# Rezoning Transportation Analysis

Petition Number: 2020-167

**From: Robyn Byers, Ph.D.**  
Robyn.Byers@charlottenc.gov  
704-336-7404

| Date     | Description       |
|----------|-------------------|
| 12-28-20 | First Review (EL) |

SCHEMATIC  
SITE PLAN  
SCALE: 1" = 30'

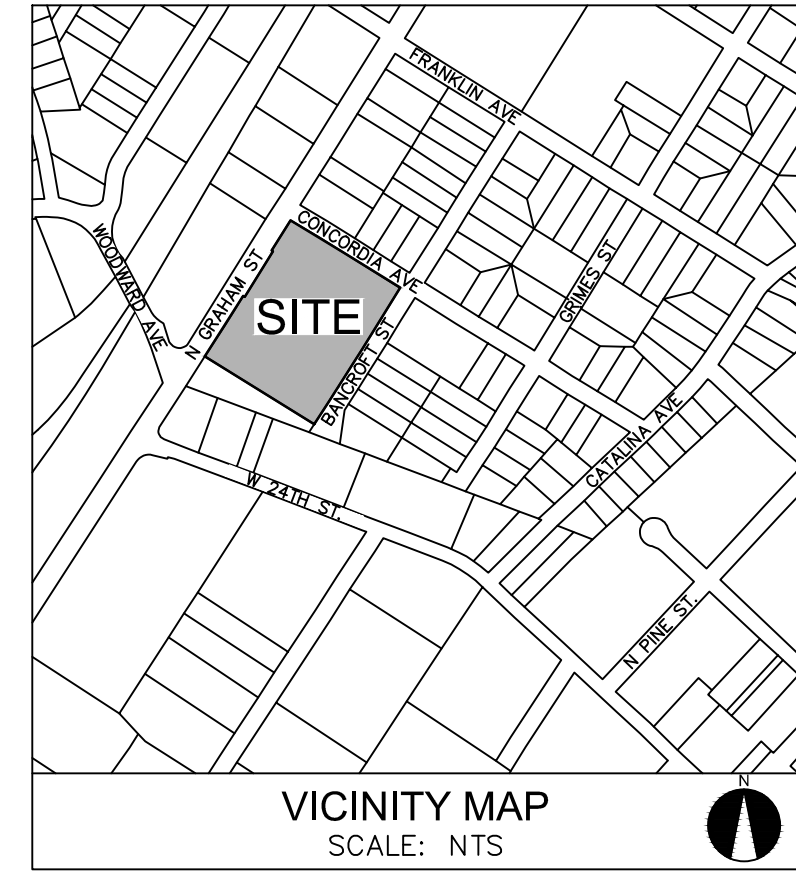
1. **Curblines:** The proposed zoning district has a setback measured from back of the existing or proposed future curblines.
  - a. **North Graham Street:** Location of curb and gutter needs to be moved 32.5-feet from road center to proposed back-of-curb, to accommodate the future 4-lane Avenue road cross section with buffered/separated bike lanes.
  - b. **Concordia Avenue:** Location of curb and gutter needs to be installed at the existing edge-of-pavement.
  - c. **Bancroft Street:** Location of curb and gutter needs to be installed along the property frontage, according to CLDSM standard detail number *U-03A – Local Residential Wide Street Typical Section*, from road centerline.

Label and dimension the curb and gutter from the centerline for each road on the site plan.

3. Revise site plan and conditional note(s) to commit to dedicate 40-feet of right-of-way from the North Graham Street centerline. Label and dimension the right-of-way from the road centerline.

4. In coordination with NCDOT, revise the site plan and conditional note(s) for the proposed access on North Graham Street to either a right-in/right-out or install a southbound left-turn lane if full movement access is desired. If the option to construct a right-in/right-out access is pursued, the median cannot restrict access to existing driveways on the opposite side of North Graham Street.

5. Site plan and conditional note(s) revisions are needed to commit to construct bicycle facilities by relocating the existing curblines to accommodate an 8-foot wide buffered bike lane along the North Graham Street property frontage, to meet the City Charlotte BIKES Plan and the goal for improved bicycle connectivity within the City, and to connect to the surrounding network.

6. The proposed dwelling units exceeds 12 per acre. Per Chapter 20 Subdivision ordinance, site plan and conditional note(s) revisions are needed to commit to construct an 8-foot planting strip and 8-foot sidewalk along Concordia Avenue and Bancroft Street. The wider sidewalk also meets the Charlotte WALKS Policy.

7. A site plan note(s) specifying dedication and fee simple conveyance of all rights-of-way to the City before the site's first building certificate of occupancy is issued is needed. CDOT requests rights-of-way set at 2' behind back of sidewalk where feasible.
8. In accordance with the Charlotte WALKS Plan, revise site plan and conditional note(s) to commit to extend the proposed sidewalk and curb and gutter to the existing stub in front of parcel PID (07909936).

9. In accordance with the Charlotte WALKS Plan, revise site plan and conditional note(s) to provide sidewalk for pedestrian circulation to proposed buildings E, F, J, and I.
10. A site plan note specifying that all transportation improvements will be approved and constructed before the site's first building certificate of occupancy is issued is needed. The petitioner may phase transportation improvements if said improvements and phasing are explicitly described in site plan notes.
